From: Andrew Hinton <[REDACTED]>
Sent: 09 July 2013 16:57
To: Janice Chapman
Subject: FAO Mrs J Chapman - 9 Shirley Close Bognor Regis PO21 4QU - P/51/13

Re - 9 Shirley Close Bognor Regis PO21 4QU - P/51/13

Proposed **Roof Plan** at 1:100 scale

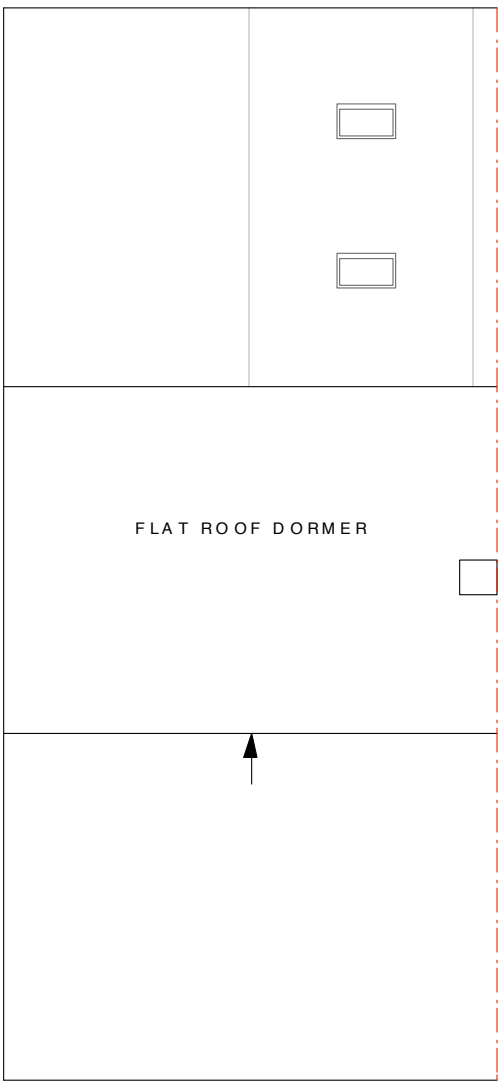
Thank you for your message and advice, yes I believe the rear dormer to be > 50 m3. Can the scheme be supported in its current guise (taking into account PD for rear dormer)? Or would you prefer we amend the scheme somehow to reduce impact on dwellings to the rear?

I have carried out a site inspection. Rather concerned regarding the dormer and the possible impact by way of overlooking on the rear gardens of properties in Eastmead (4 objections so far). Presumably the dormer is under 50 cubic metres so this may be allowed under Permitted Development.
